Contact: Patrick Warren on 9725 0215
Your Ref: SSD 6525 Mod 2

ADVICE ON SSD 6525 MODIFICATION 2 – BORAL PROCESSING FACILITY-GREYSTANES SOUTH INDUSTRIAL ESTATE

This submission relates to an SSDA application for construction of a weighbridge and extension to 24-hour operations for the Boral Processing facility at Widemere Road, Wetherill Park. Council would not support any increase to night-time vehicle movement due to associated noise impacts to sensitive residential receivers at Victoria Street and Hassall Street, Wetherill Park. It is therefore recommended that the SSDA be conditioned to limit vehicle movements. Further to this air quality and traffic impacts have been considered below.

Site layout - current operations

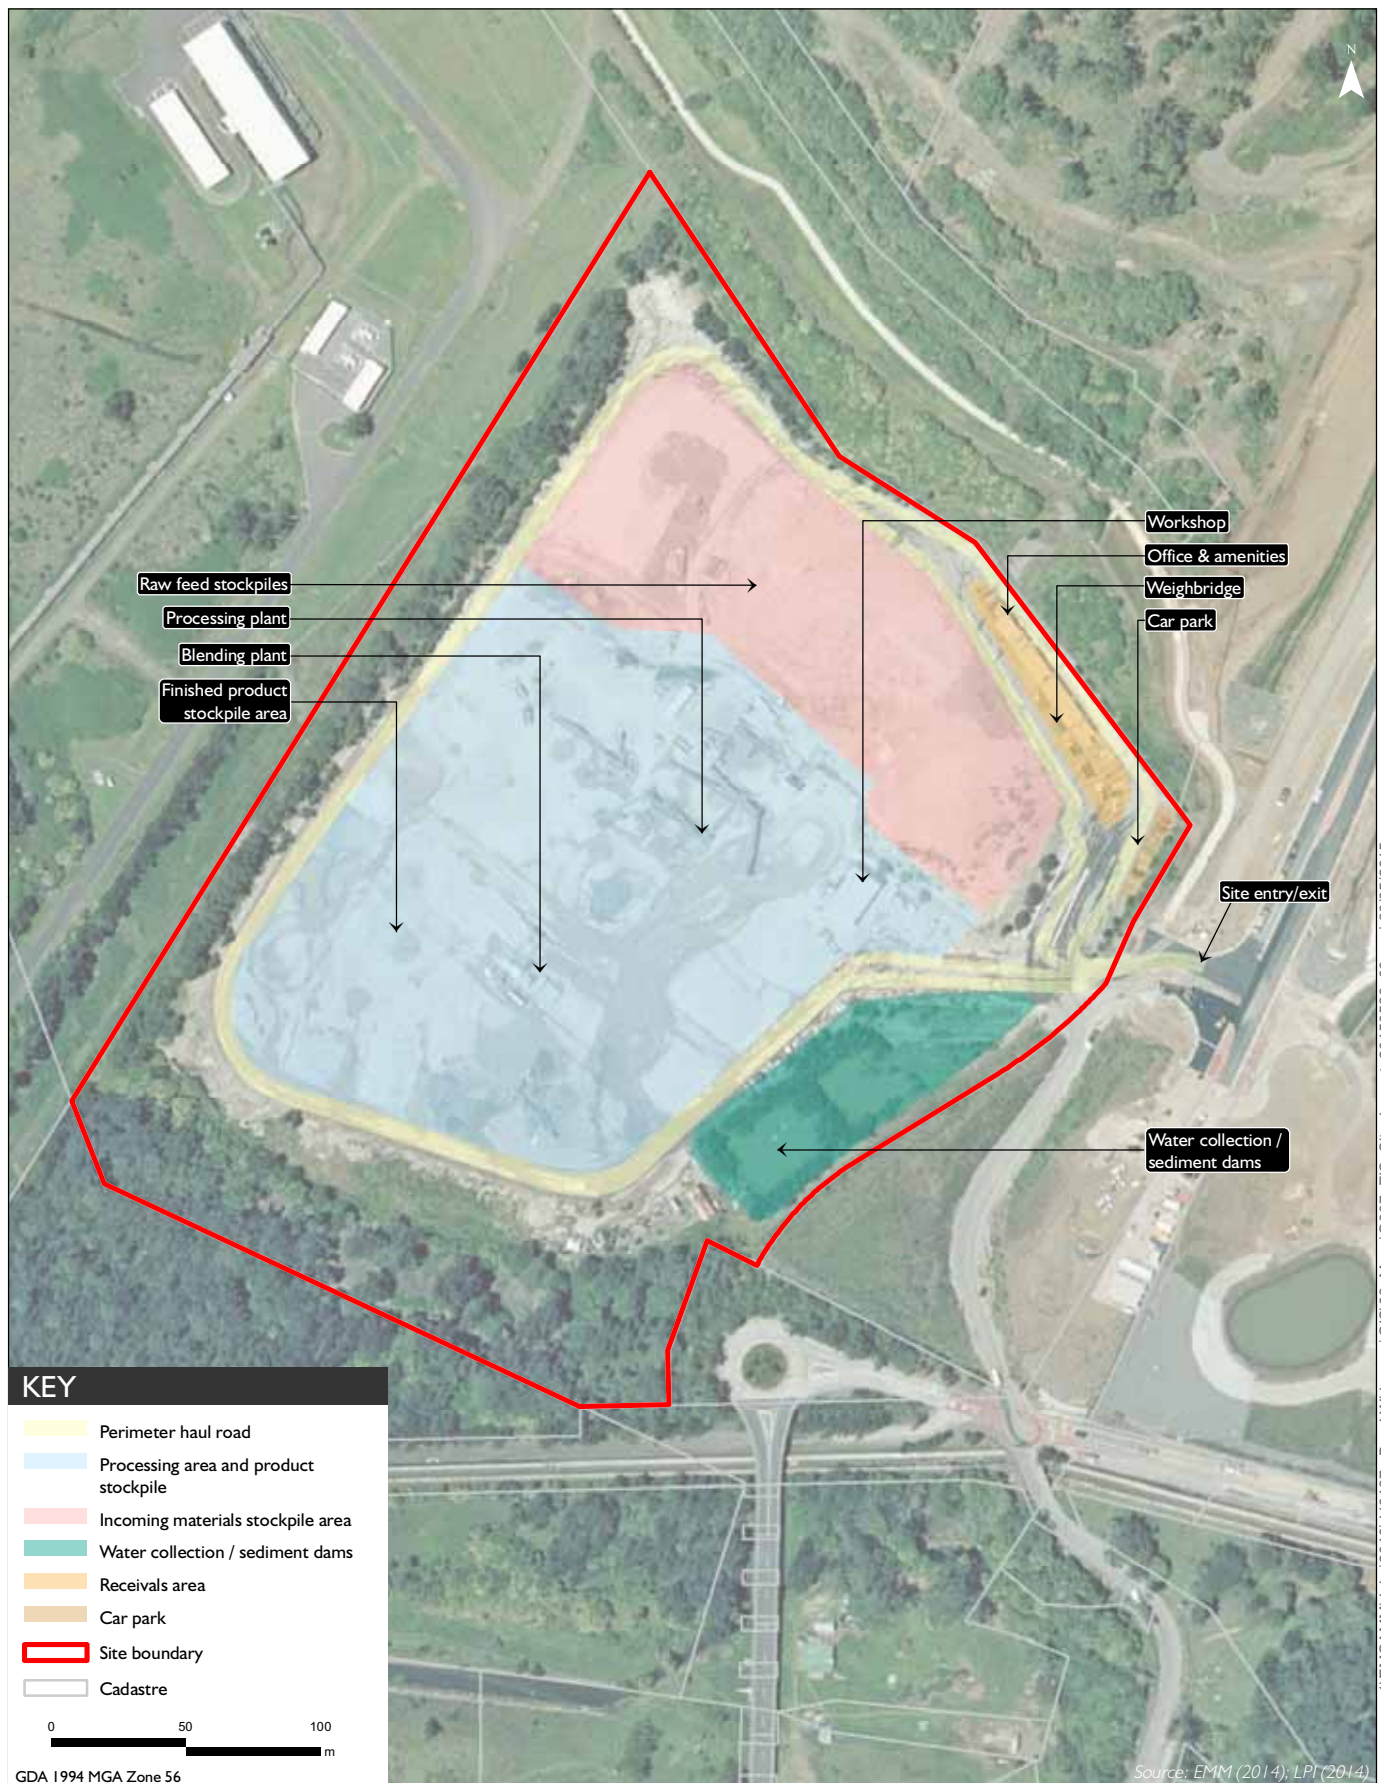
- 5. Provision of Site Plan** – The applicant shall provide a site plan showing where provisions would be made to accommodate heavy vehicle unloading and loading activities within the site. Service vehicles shall only carry out loading and unloading activities from the designated loading areas and shall not obstruct the flow of traffic within the site.

Internal traffic circulation
Widemere Recycling Facility
Environmental Impact Statement
Figure 2.3

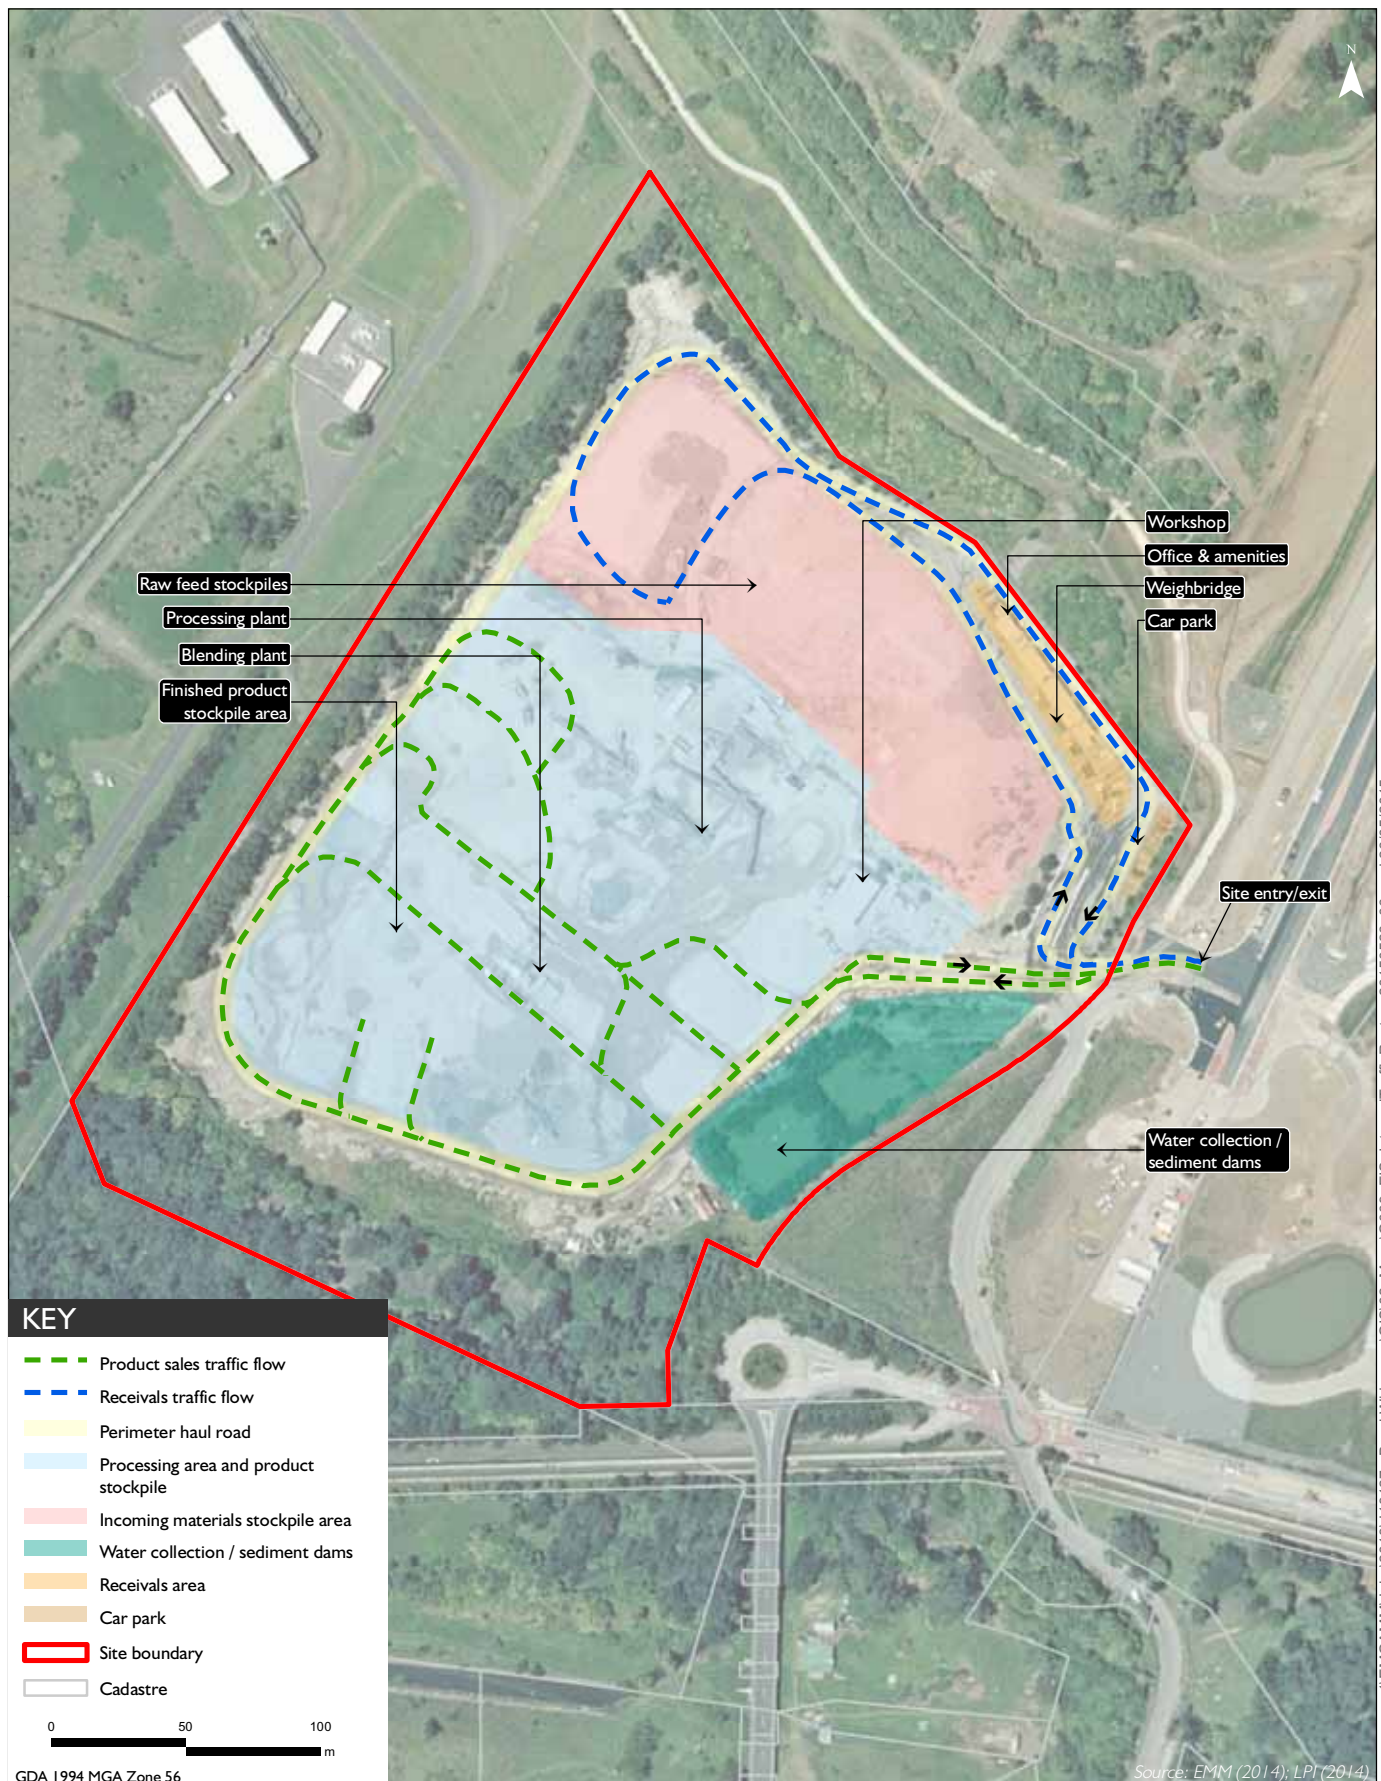
- 3. Swept Path Diagrams** - The applicant shall submit a swept path diagram to demonstrate that the largest vehicle can manoeuvre within the site without being impacted by vehicles parking within the site.

- 4. Provision of Vehicle Breakdown** – The applicant shall provide a breakdown of the types of heavy vehicles accessing the site and the expected daily and weekly movements of each vehicle to Council for assessment. This is to ensure that vehicles accessing the site will be managed in a way that they will not affect traffic circulation within the site, including vehicles queuing out onto the external road network.
